j arthur blessen engineering
architect engineer
2429 Zena Lona NE
(505) 293-1477
Albuquerque, NM 87112

March 16, 2015

file: E17/D034C
re: Array Technology Paving
City of Albuquerque Comments

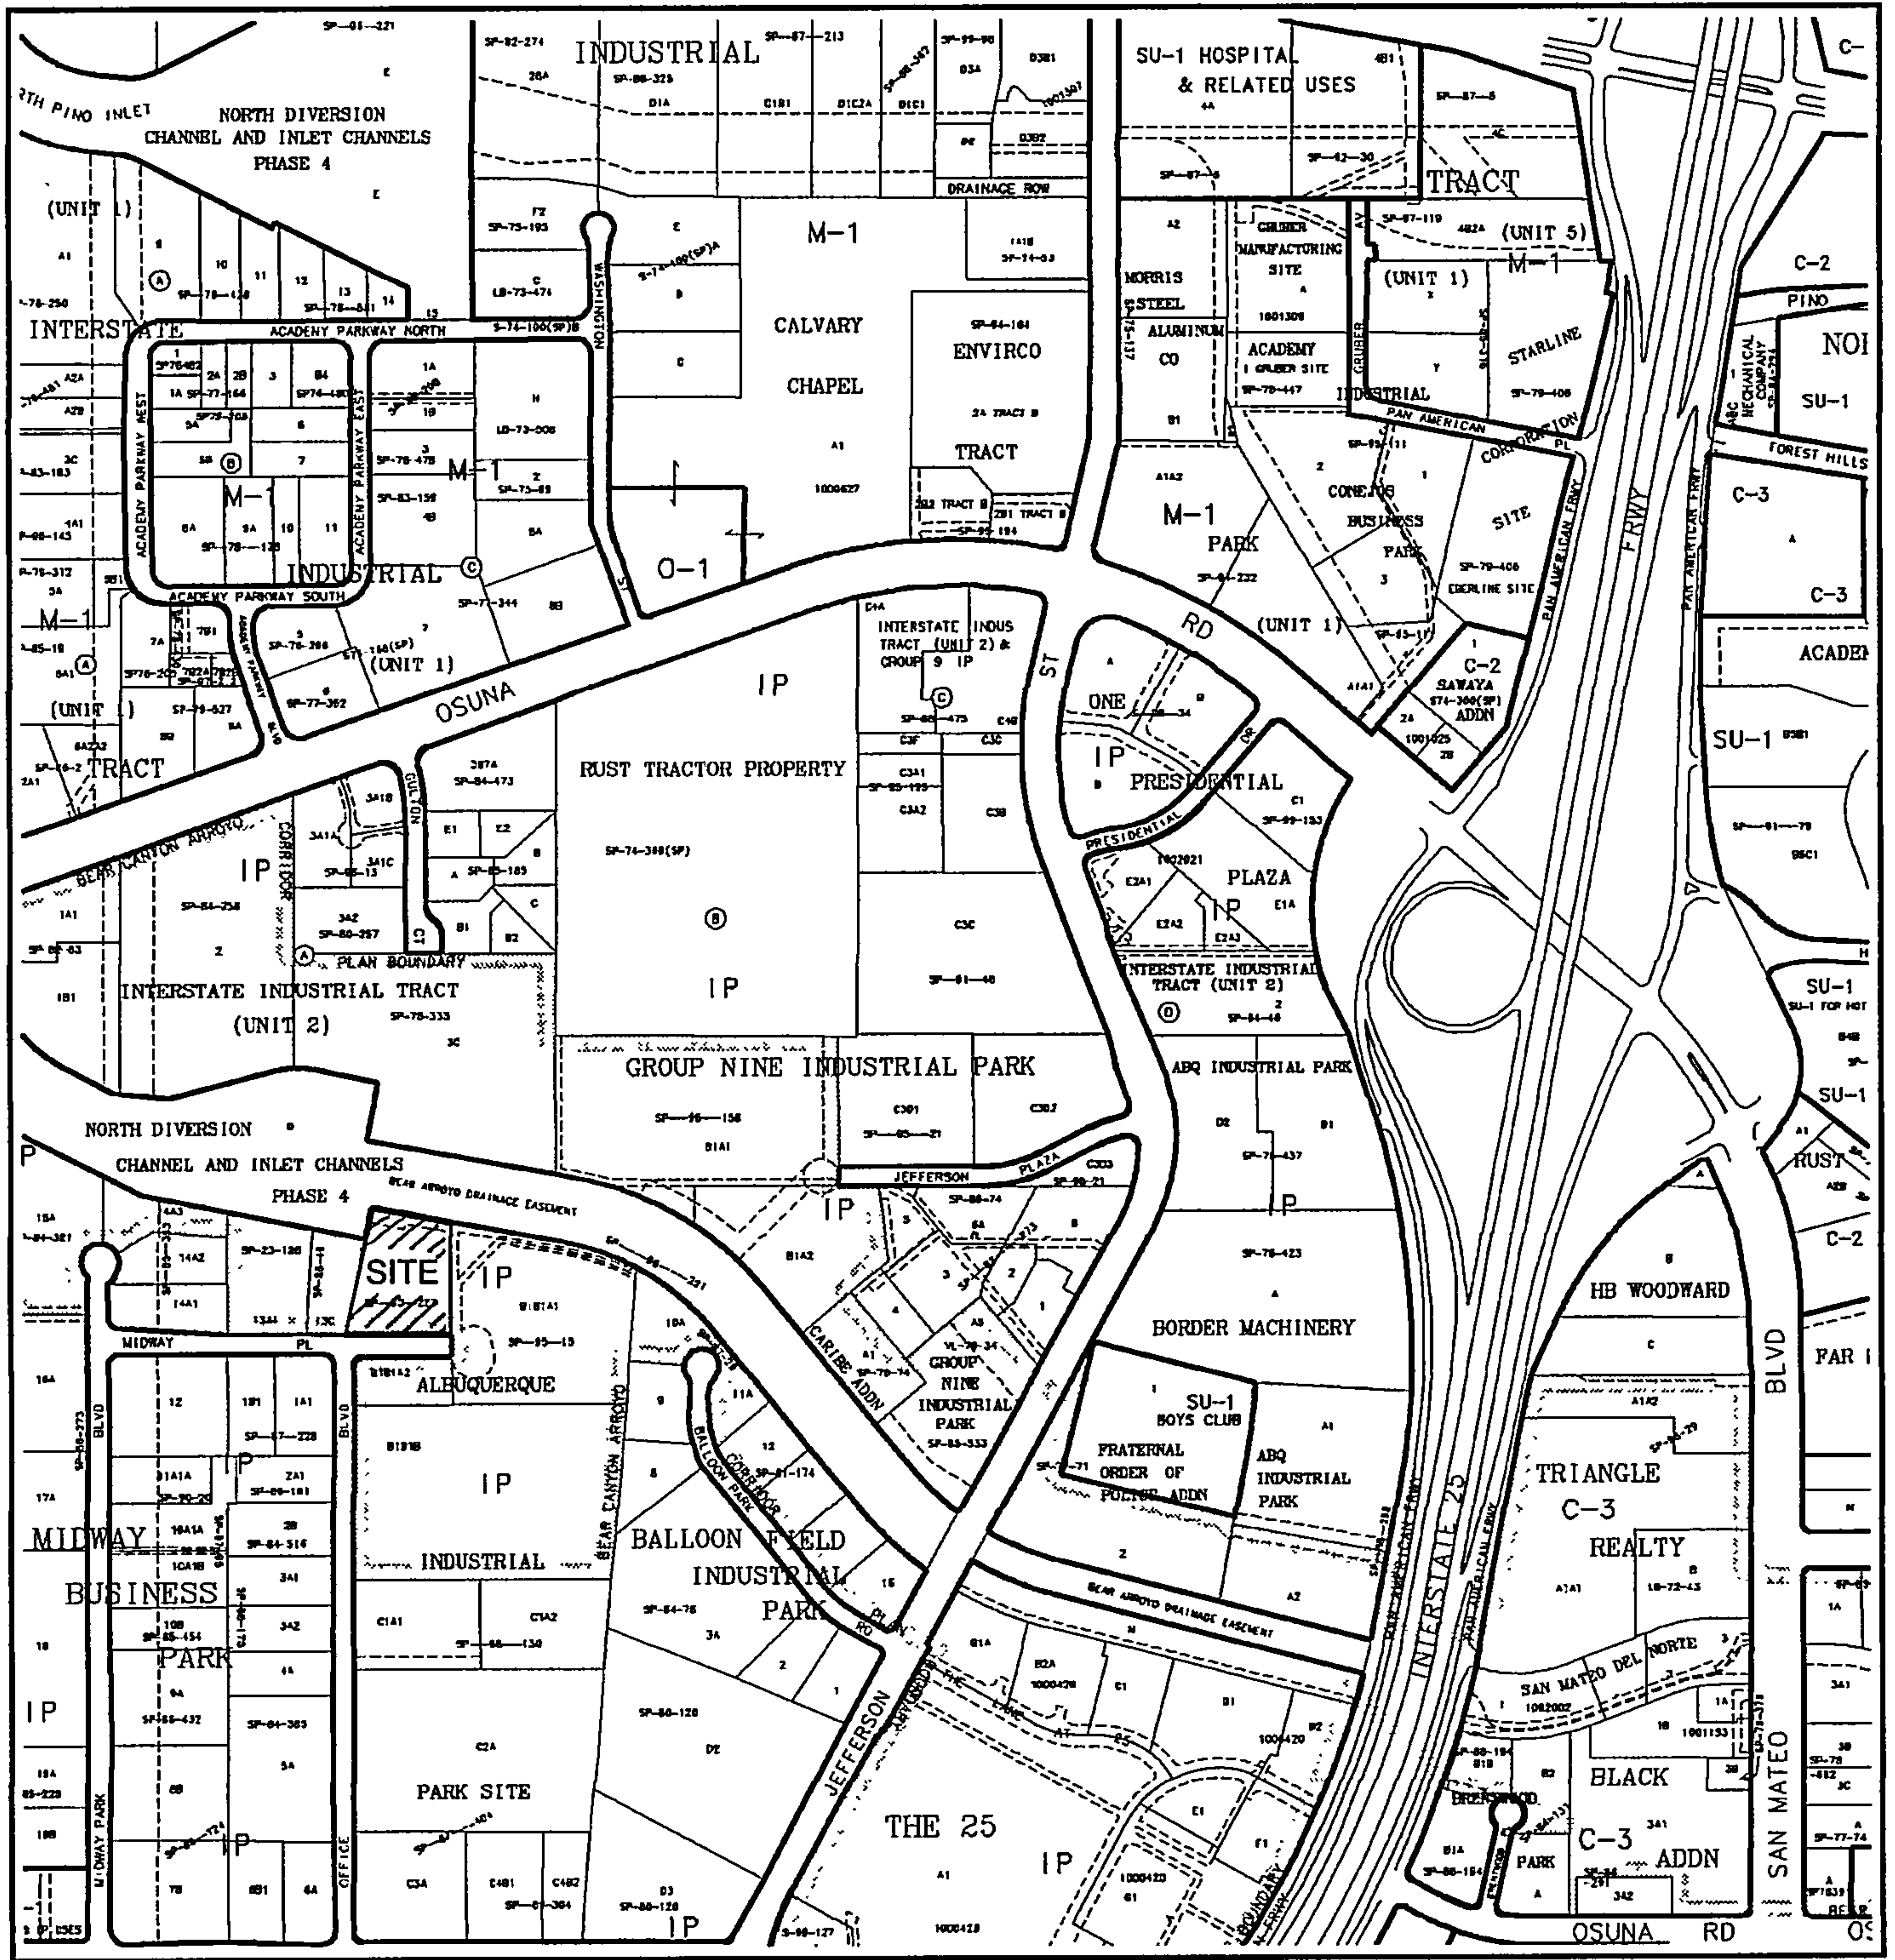
The size of detention Pond A has been increased to provide a portion of the pond below the discharge to retain the first flush volume of the added impervious area associated with paving the storage yard area. (See attached drawings).

POND A - FIRST FLUSH REQUIREMENTS PROPOSED IMPROVED AREA
 BASINS B-3, AND C-1
 ADDITIONAL IMPERVIOUS AREA (D) = 22,140 SF
 VOL (ff) = 22,140 * 0.34" / 12 = 627 CF
